Environmental Impact Statement for Hume Coal Project (SSD 7172) and related Berrima Rail Project (SSD 7171): Request for Submissions

I refer to your correspondence received on 3 April 2017 requesting a submission and recommendations, if required, from the Heritage Council of NSW for the Environmental Impact Statement (EIS) for both the Hume Coal Project (SSD 7172) and the Berrima Rail Project (SSD 7171).

Rajeev Maini
Acting Manager, Conservation
Heritage Division
Office of Environment & Heritage
As Delegate of the Heritage Council of NSW
17 July 2017

Indicative mine infrastructure overlaid on the 1949 aerial photograph

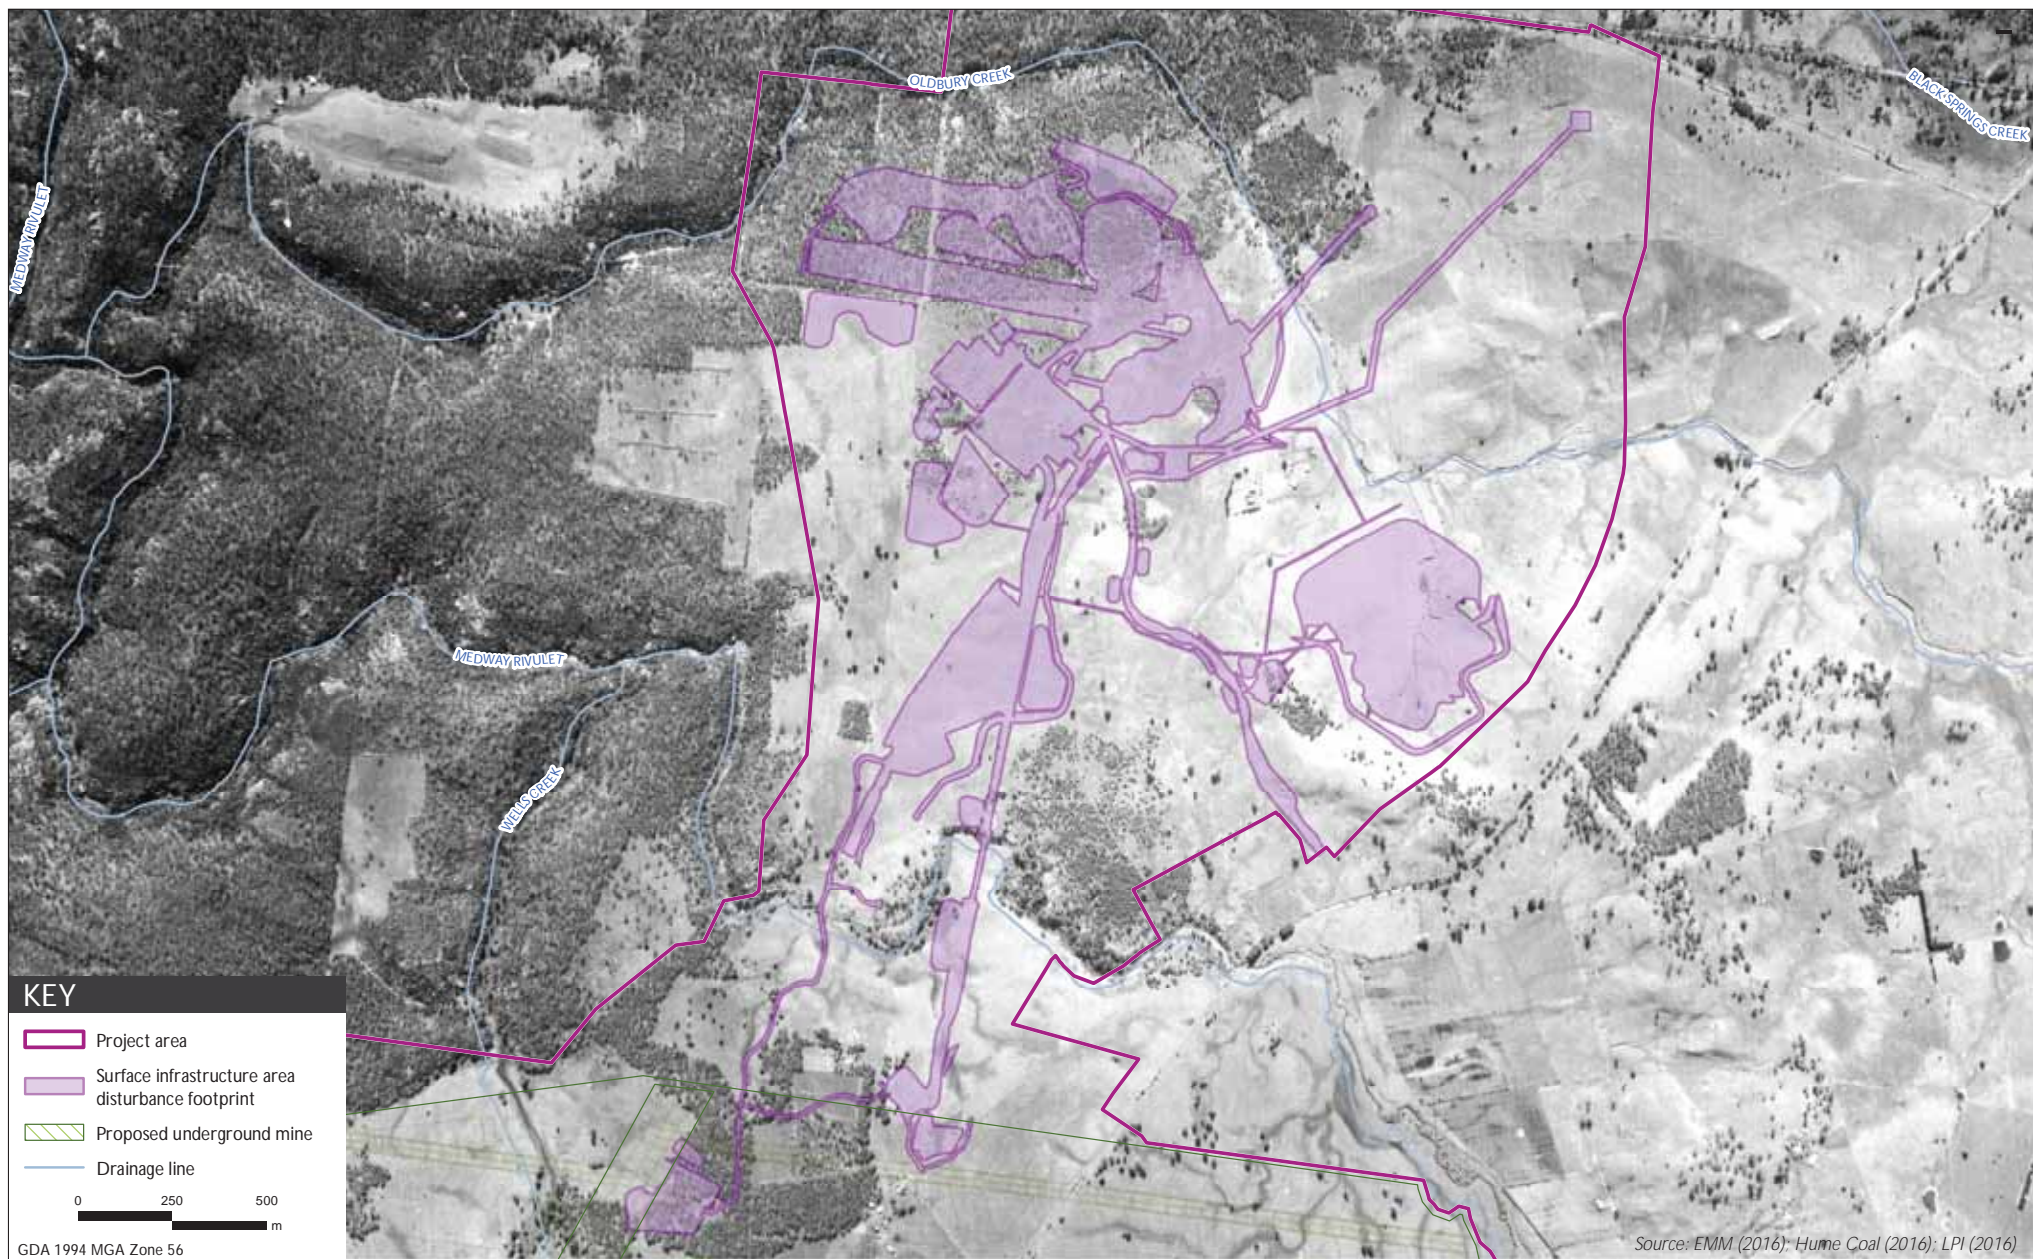
The EIS states there are two potential archaeological sites affected by the project which retain archaeological relics within the meaning of the *Heritage Act 1977*. These sites are identified as a former homestead *Mereworth 1* which dates from the 1820s, and *Evandale scatter HC_127*. It is noted the *Three Legs of Man Inn* is identified outside the study area, however it is unclear how subsidence to this site would be avoided by the proposed mining activity. Due to the access restrictions referred to in the EIS it is also unclear how the EIS can have adequately identified and assessed archaeological potential within the subject land. It is further noted that the 'local heritage items' Sutton Farm, The Pines, Comfort Hill and The Harp all date to the 1820s and 1830s and are highly likely to retain their own historical archaeological resources associated with the extant intact structures. Newbury and the Eling Forest Winery Group are both identified in the EIS as highly likely to retain research potential. These items are within the impact area, however, the EIS is silent as to the likely impact that the proposed mining activities may cause to likely subsurface archaeological deposits associated with these items.

The EIS has not demonstrated an adequate assessment of the study area to clarify there are no additional historical archaeological sites which may fall within the project boundary. The EIS is also not supported by a separate Historical Archaeological Assessment to clarify this. Therefore, given the early cultural landscapes which date from the 1820s onwards, it is recommended that:

Mine infrastructure directly adjacent to Mereworth house and garden

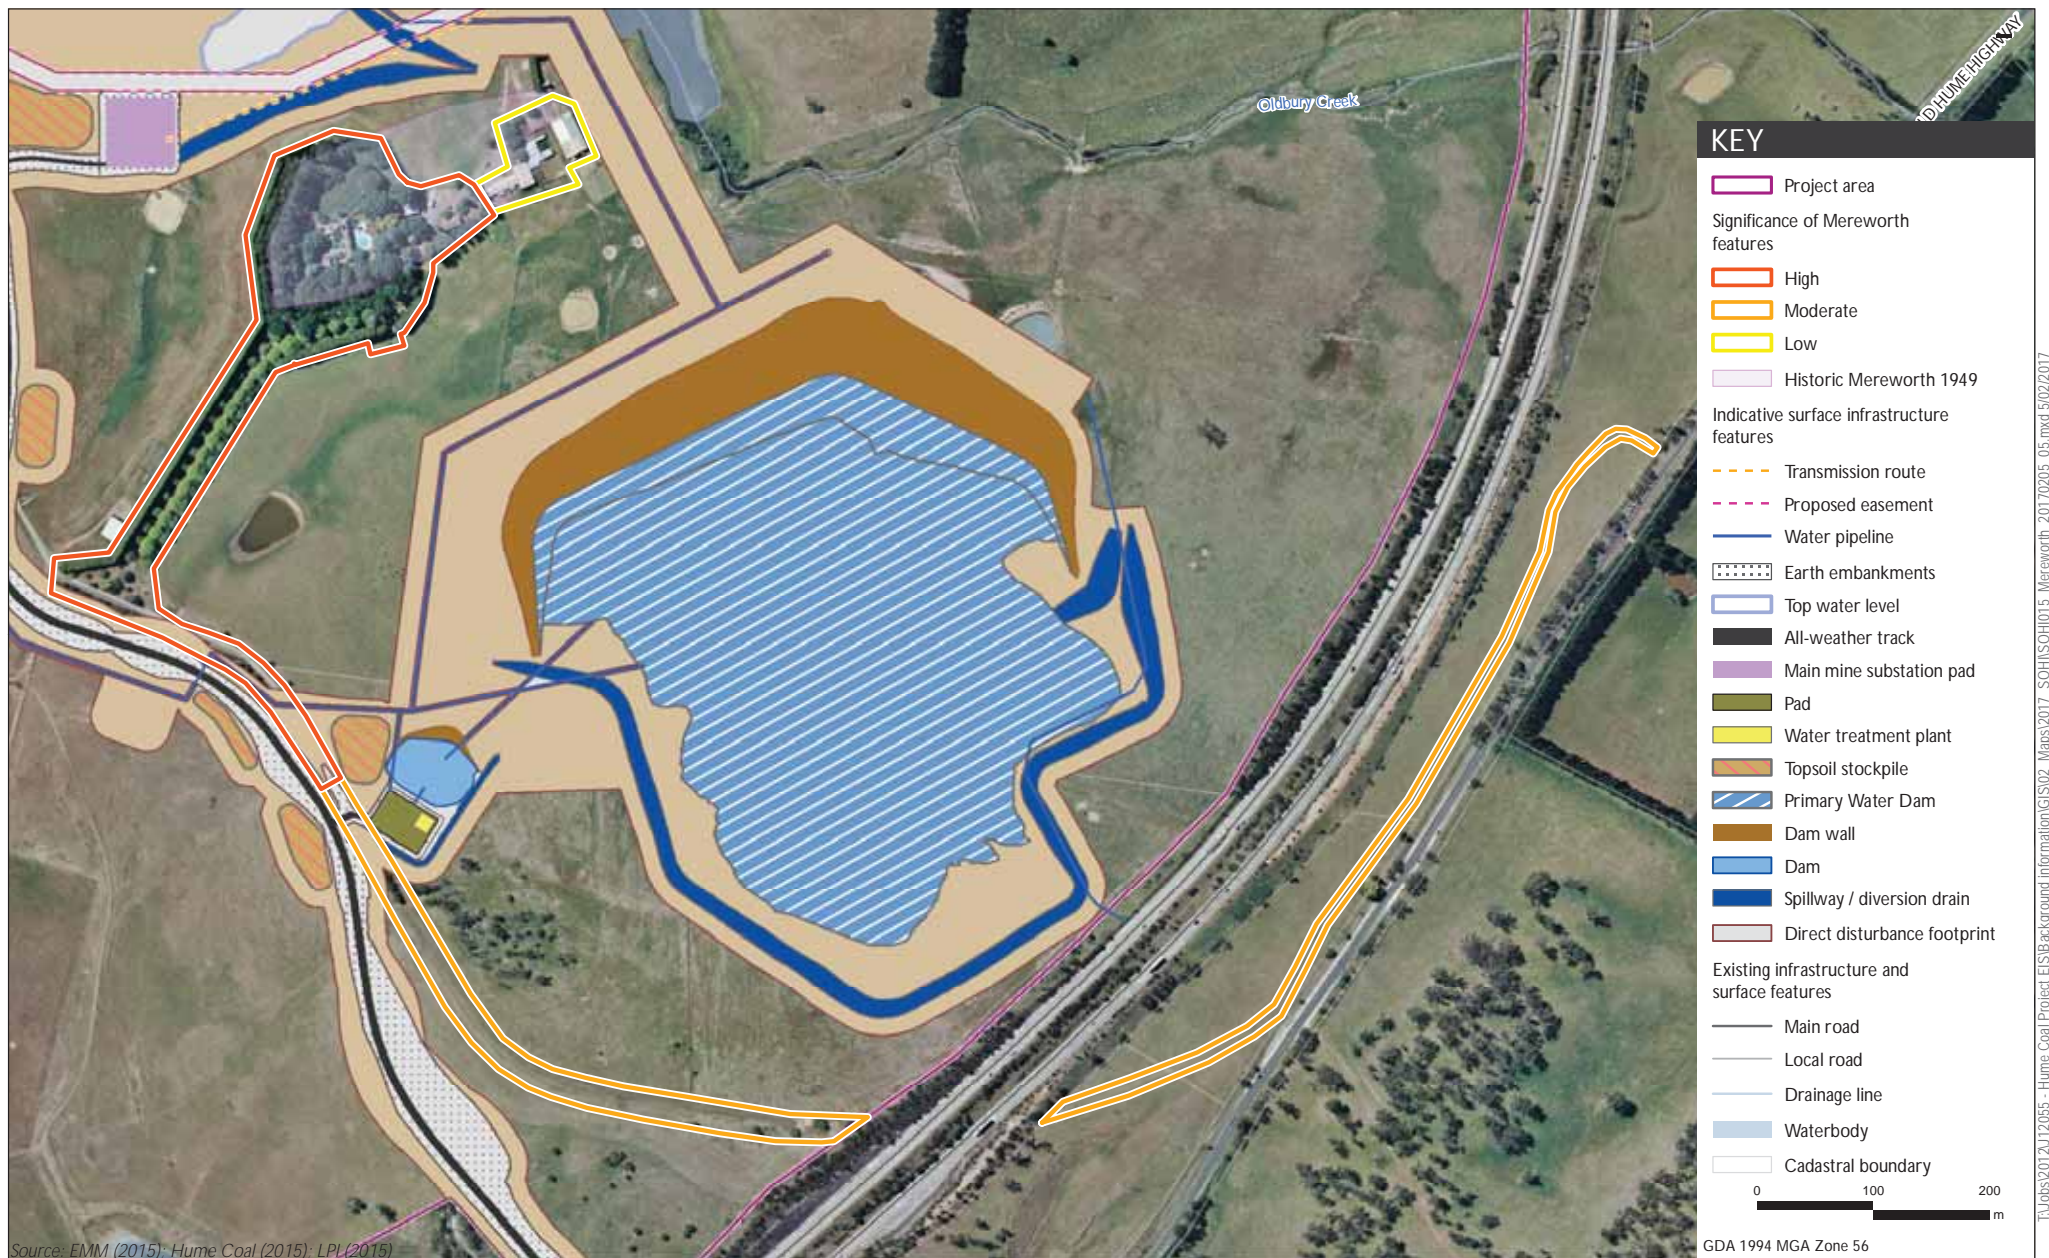
There is concern about potential adverse impact of the proposal on a key feature of Sorenson's garden design, the view to the north and east. The coal handling infrastructure, buildings, the powerlines, water infrastructure and stockpiles north of Mereworth will, for the life of the mine, has a potential to adversely impact the quality of Sorenson's garden design which borrows the long open view to the north and east. There is also insufficient information in the Statement of Heritage Impact to understand the height and size of the mine's above ground workings and structures north of Mereworth. Therefore, it is recommended that:

- **The EIS should firstly include a comparative analysis of Sorenson's design at Mereworth within his whole body of work for an up-to-date understanding of Mereworth's level of significance, ie state or local. Only then can the assessment discuss any potential impact with greater certainty and recommend effective measures to prevent a negative impact. The analysis should be undertaken by a heritage landscape consultant with demonstrated experience with similar historic landscapes. Then, based on the comparative analysis, the EIS should reassess the impact of the Hume Coal Project (SSD 7172) above ground workings in greater detail.**

- **The following three views need to be accurately rendered and presented at least at A4 size for clarity:**
 - **the view from within Sorenson's Garden out to the north and east;**

- **the view to Mereworth House and Garden from the highest point on the original Mereworth drive; and**
 - **the view to Mereworth House and Garden from the Old Hume Hwy parallel to the original drive, now disused.**

These views need to accurately illustrate the appearance, size, scale of the mine's above ground infrastructure and its proximity to the House and Garden. This is important so that the assessment of any impact is correct and negative impacts on these views can be prevented. The applicant should provide this analysis and subsequent assessment prior to determination of the application, so that it informs the conclusion of any determination.
